Proposed Residential  
Development at Dyke Road,  
Co. Galway

Stage 1 Road Safety Audit

Document Ref:	P24-092-PMCE-XX-XX-RP-SA-3_0001
---------------	---------------------------------

LOCATION PLAN
1:500

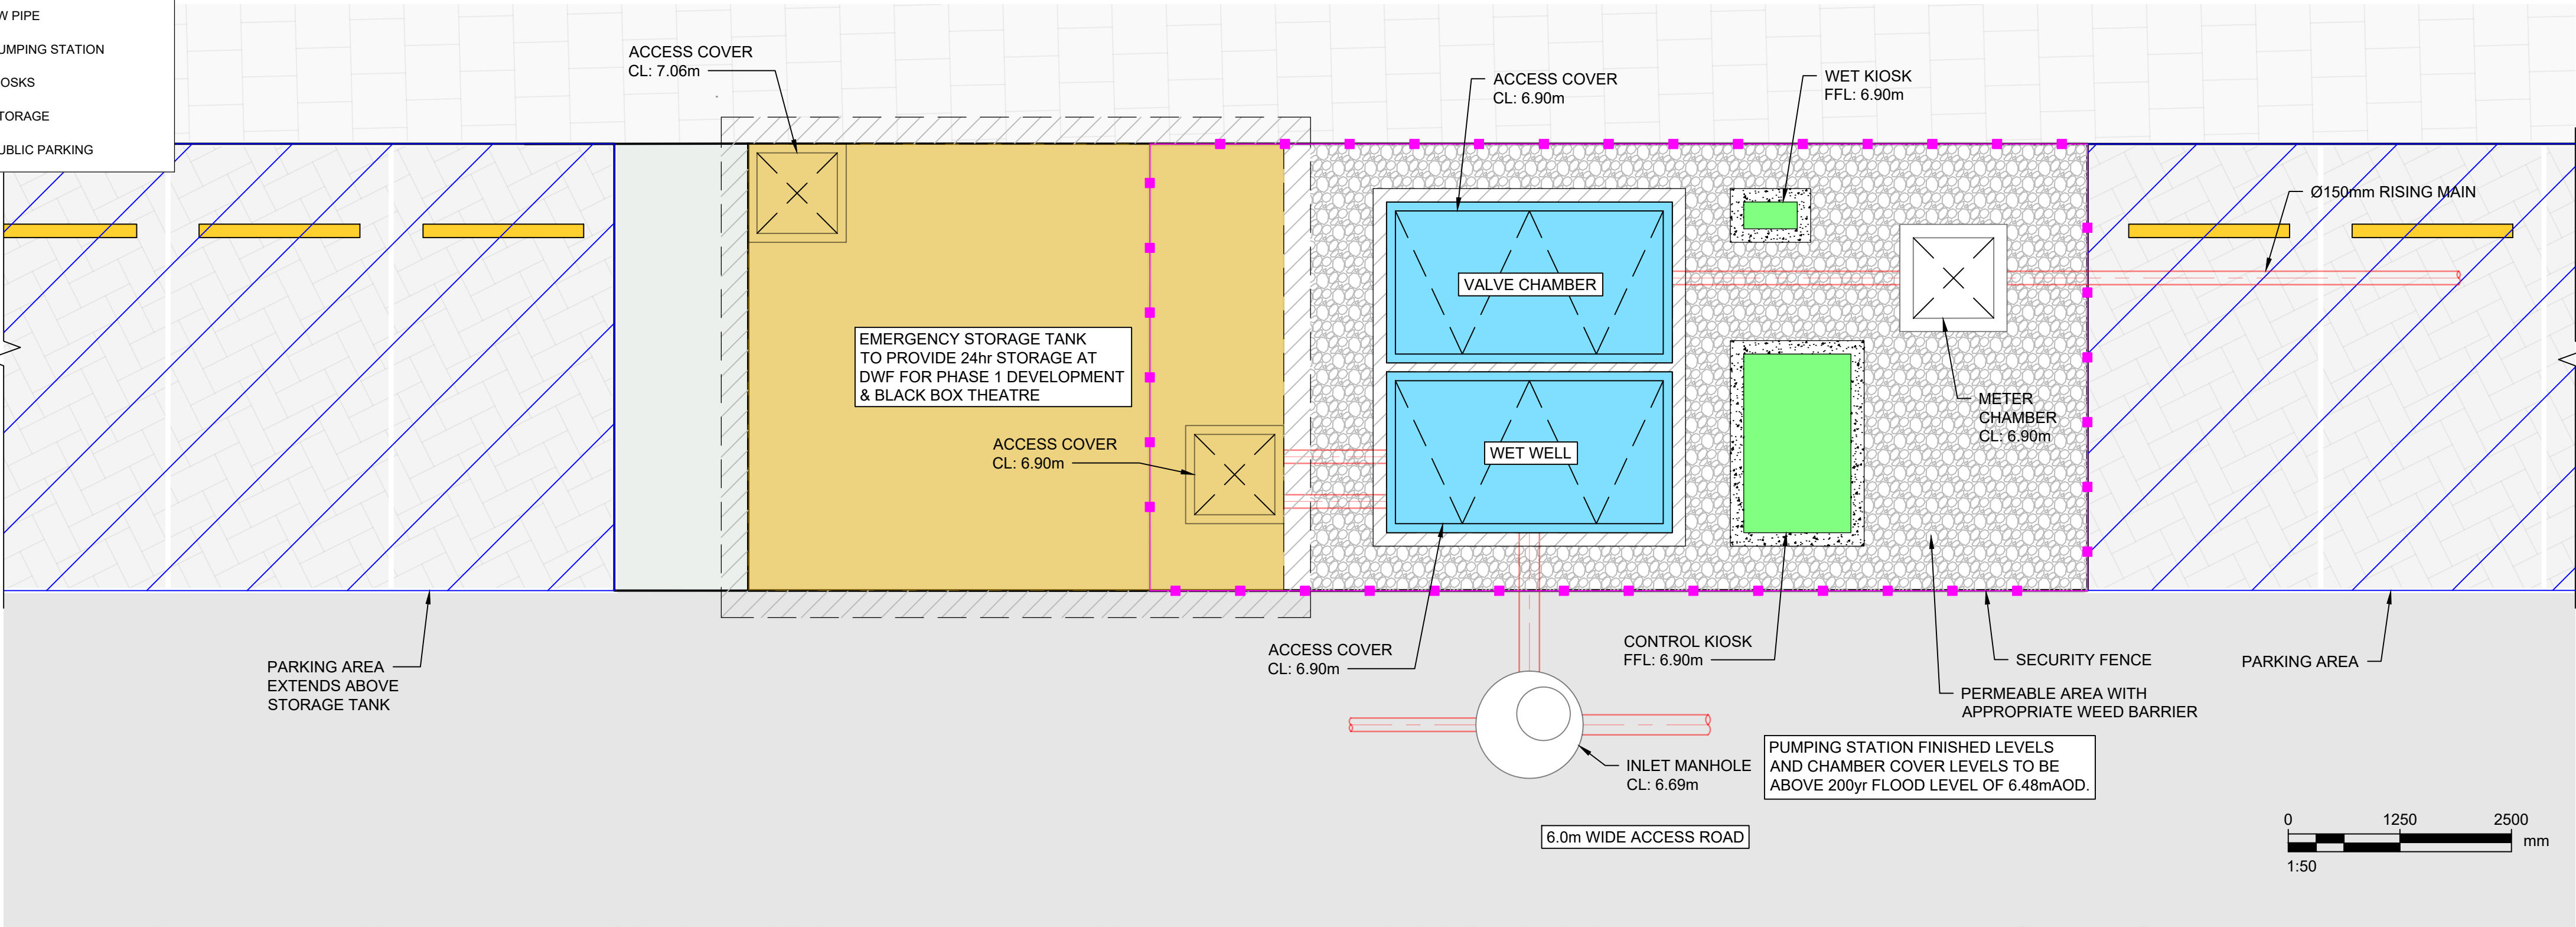
*Summary:* The proposed WWPS may be located such that it could obstruct the visibility of a driver exiting the adjacent parking space.

A WWPS has been indicated on the southern side of the development's southern access road, located within the row of perpendicular parking spaces on this side of the access road. The layout of the WWPS is unclear however it is assumed that a building, or fenced, area would be provided at this location.

The location of the WWPS may be such that it may obstruct visibility for a driver exiting the adjacent parking space, at its western boundary, particularly when reversing. This may lead to drivers entering the access road ahead of oncoming vehicles, resulting in potential low-speed side-on collisions.

An assessment should be undertaken to confirm that a driver exiting the adjacent parking space, particularly when reversing, would have sufficient visibility towards a driver approaching from the east.

Where sufficient visibility cannot be achieved measures should be provided, such as providing a grassed buffer area on the western side of the WWPS, similar to that provided on its eastern side, to maximise visibility.

Section A-AA

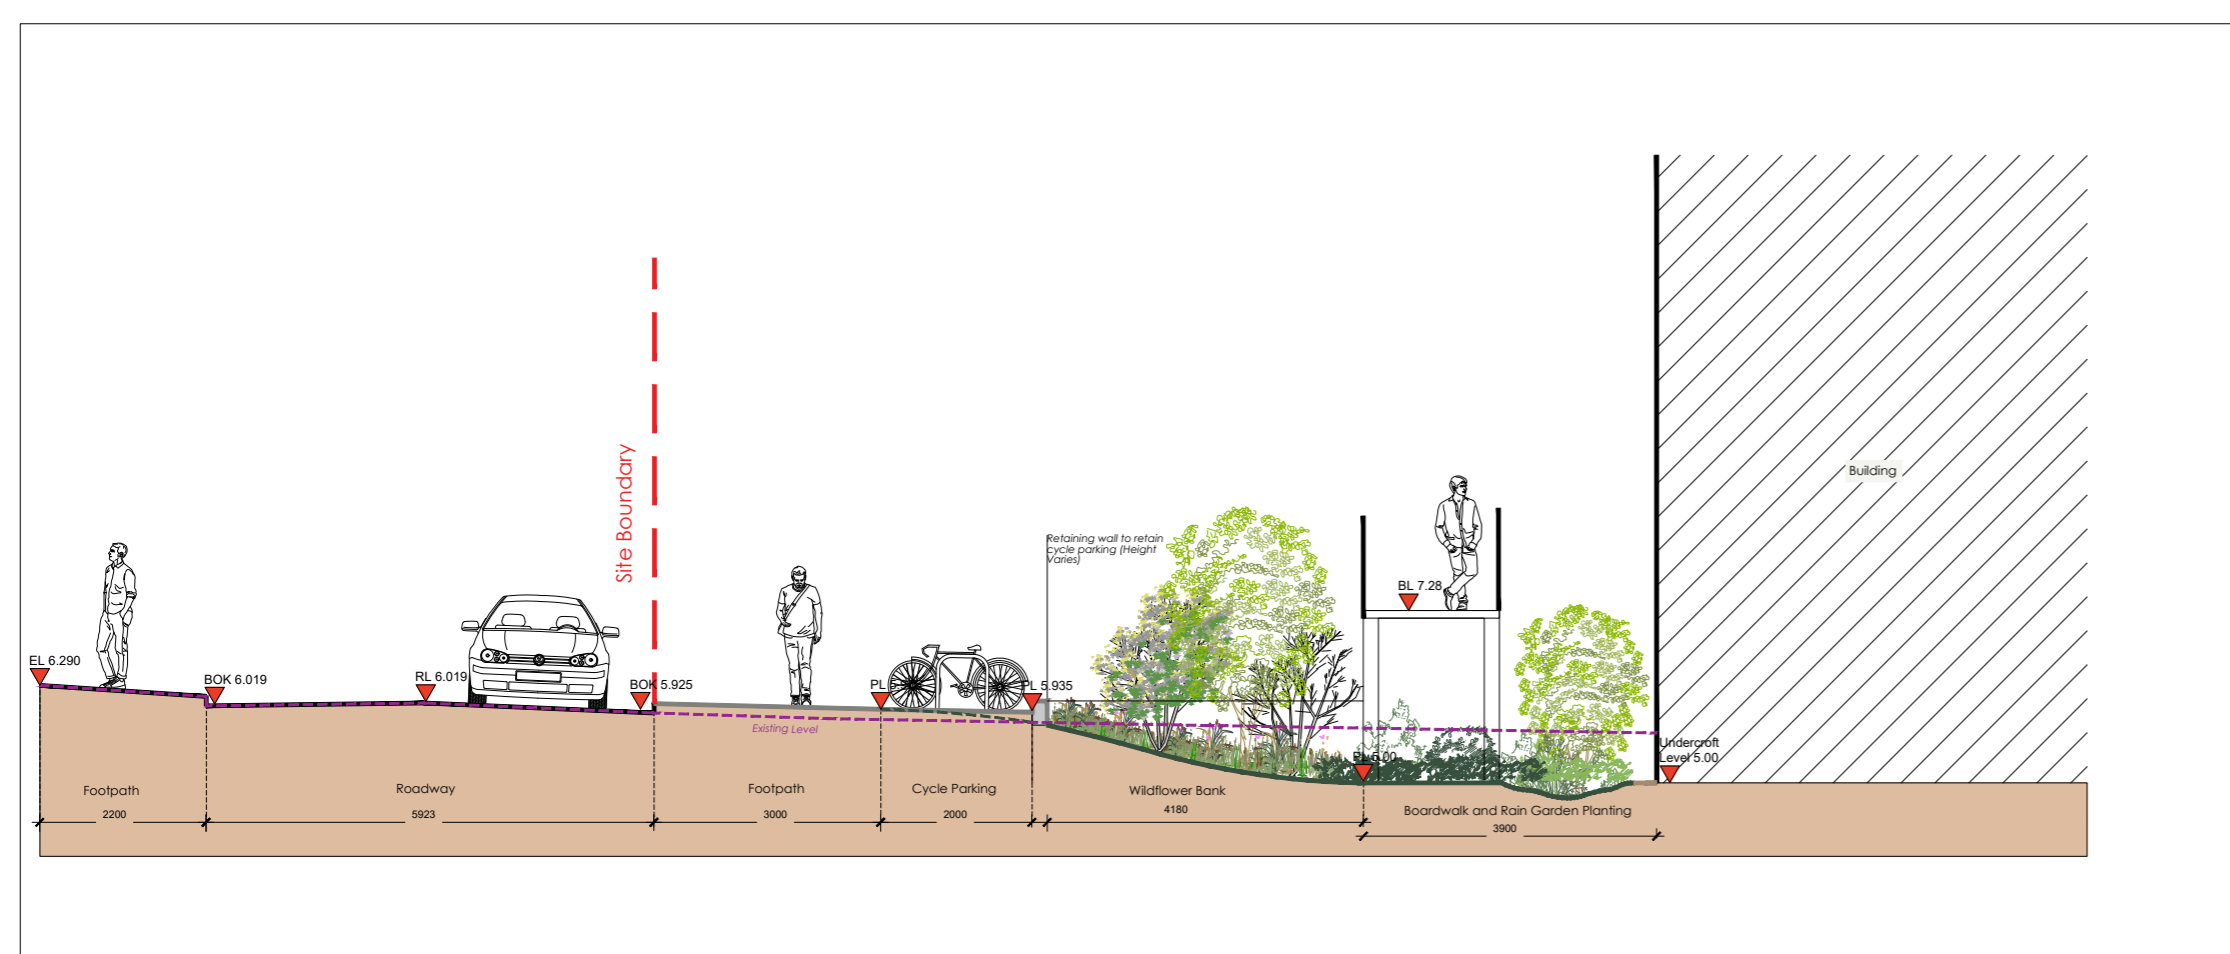
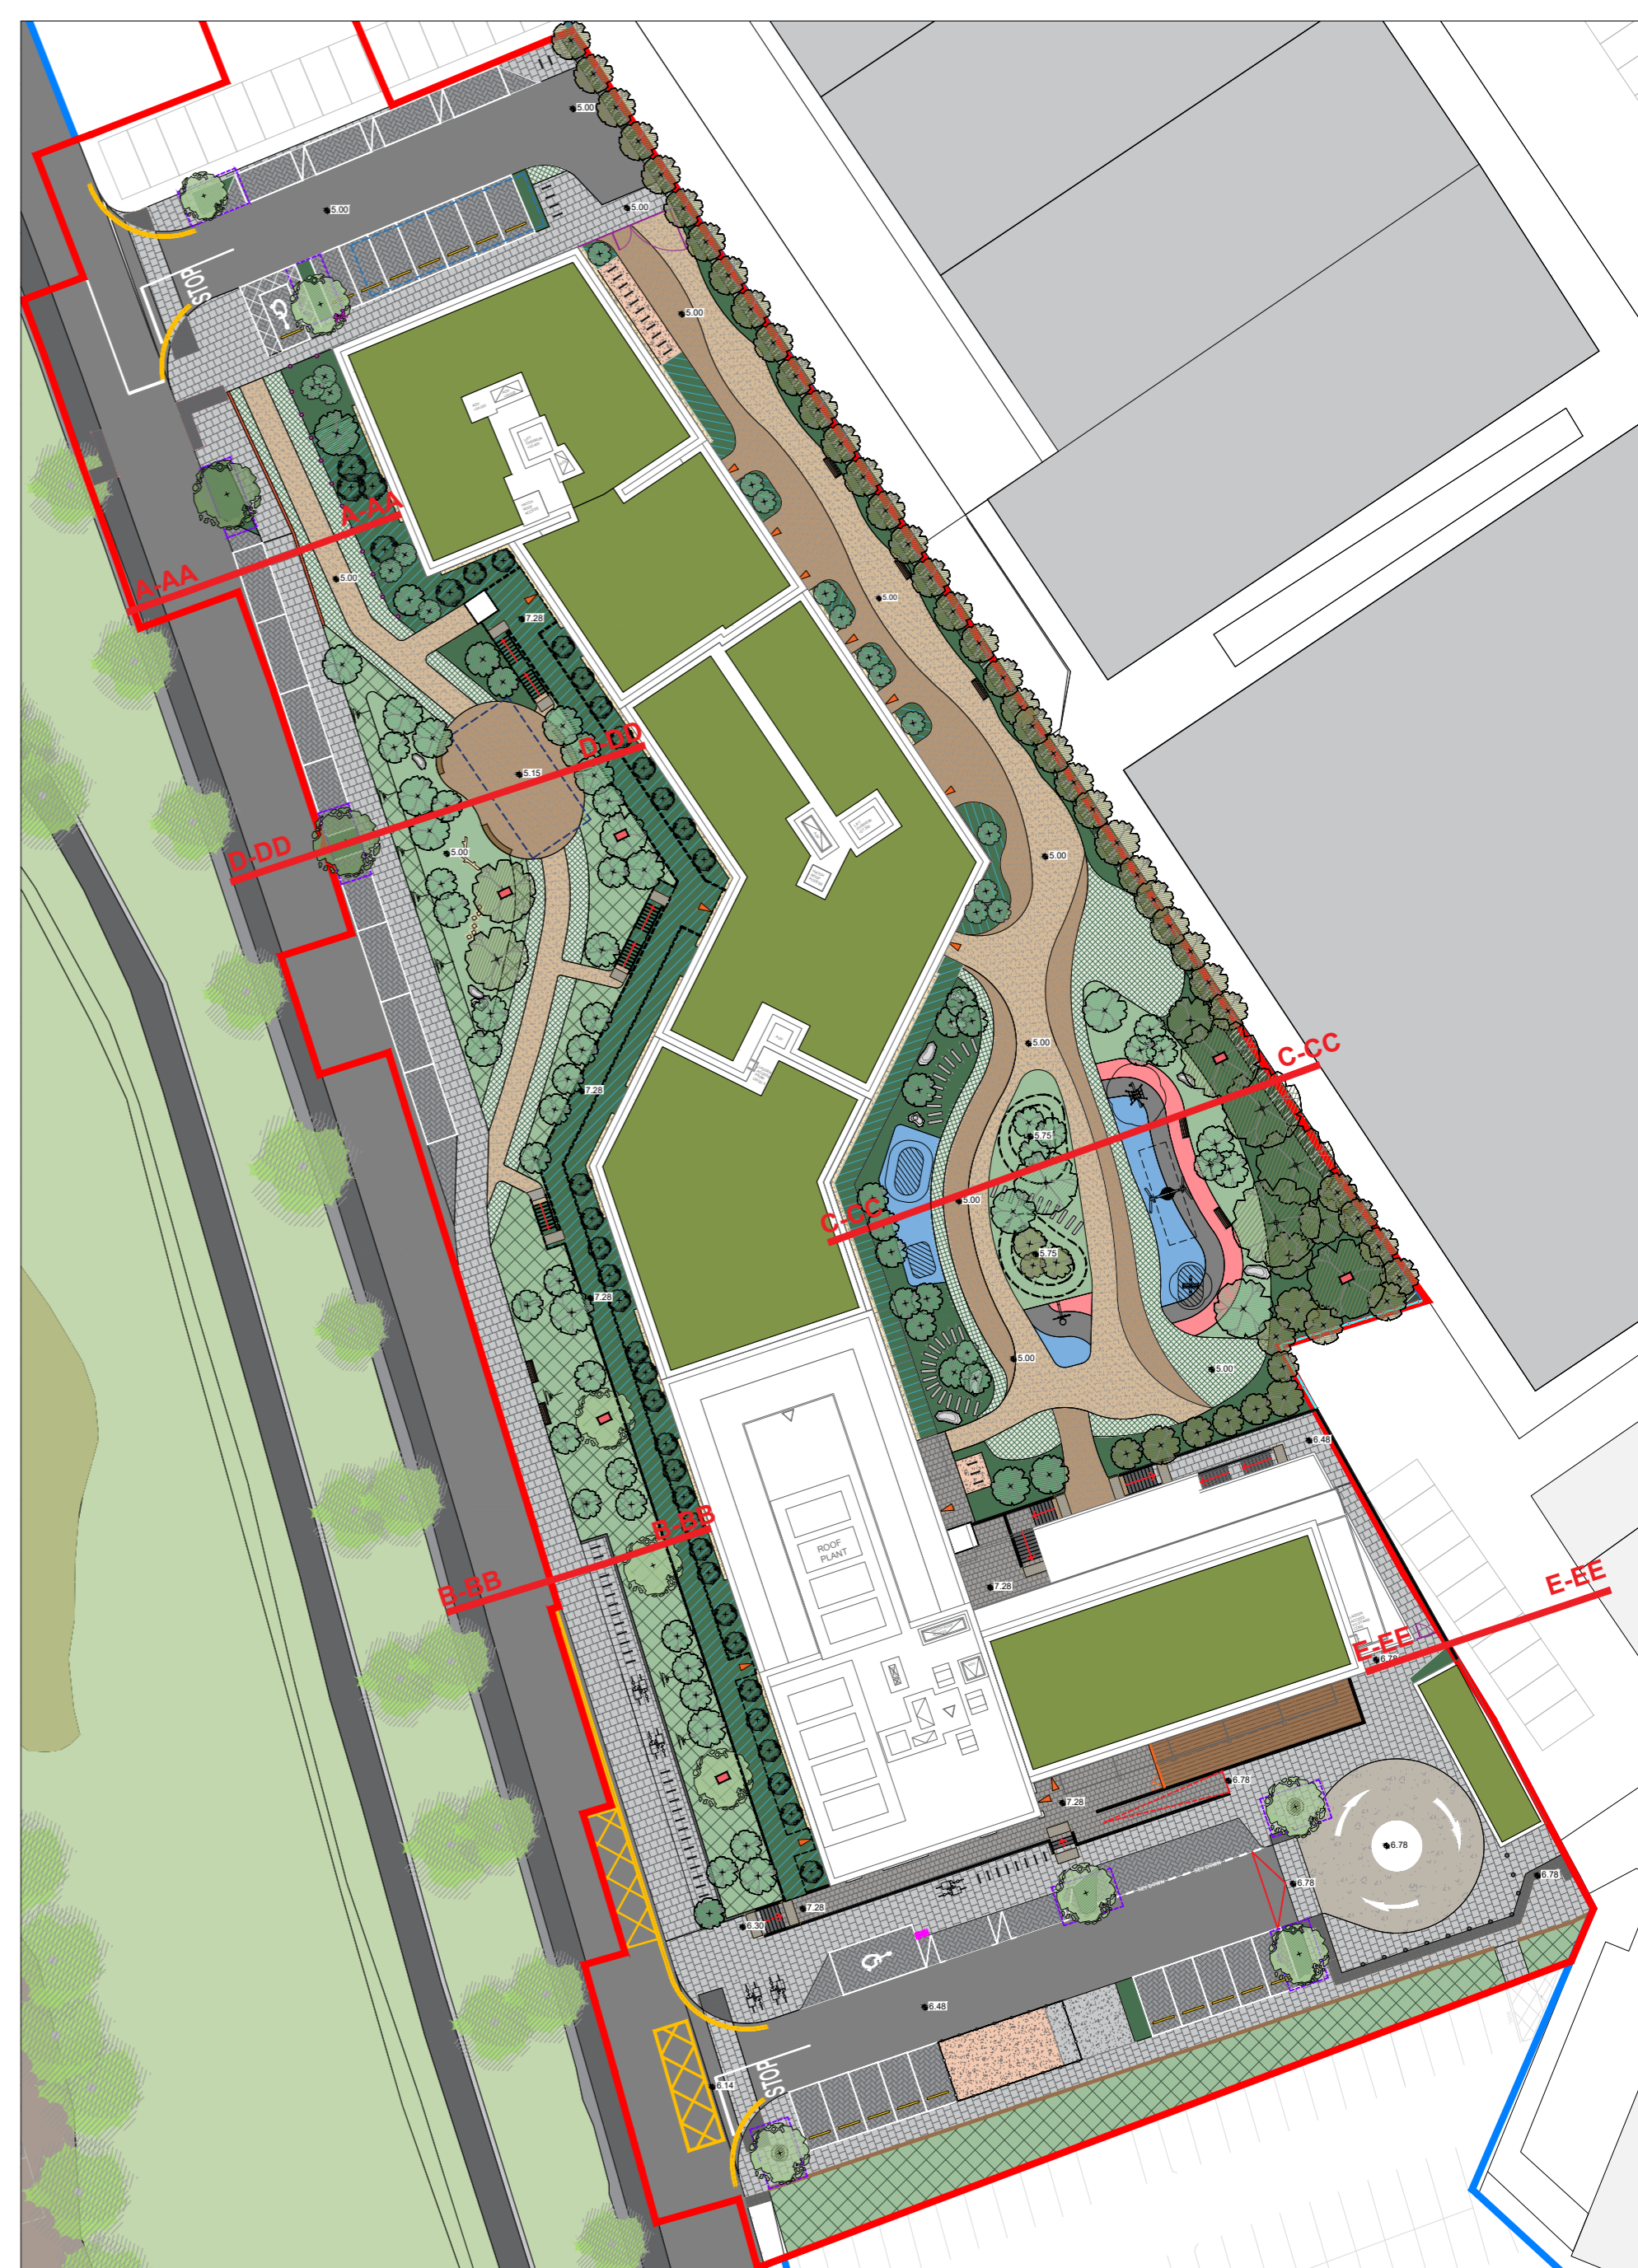
*Location:* Drawing No. 1911\_PL\_S\_01 (Rev. 0)

*Summary:* No edge protection has been indicated along the retaining wall where there is a drop in height to its rear.

A low retaining wall has been indicated to the rear of the footpath on the eastern side of Dyke Road for a short distance extending southwards from the proposed development's northern access. The top of the retaining wall is indicated as being level with the adjacent footpath, however a vertical drop of 600mm has been indicated between the footpath and the Grasscrete material within the development (see Section A-AA on Drawing No. 1911\_PL\_S\_01 (Rev. 0)), and no edge protection has been indicated at this location.

This may lead to pedestrians, particularly the visually-impaired, inadvertently straying from the footpath and falling to the rear of the wall resulting in a risk of personal injuries.

Edge protection should be provided along the top of the retaining wall at this location throughout the extent of the exposed level difference.
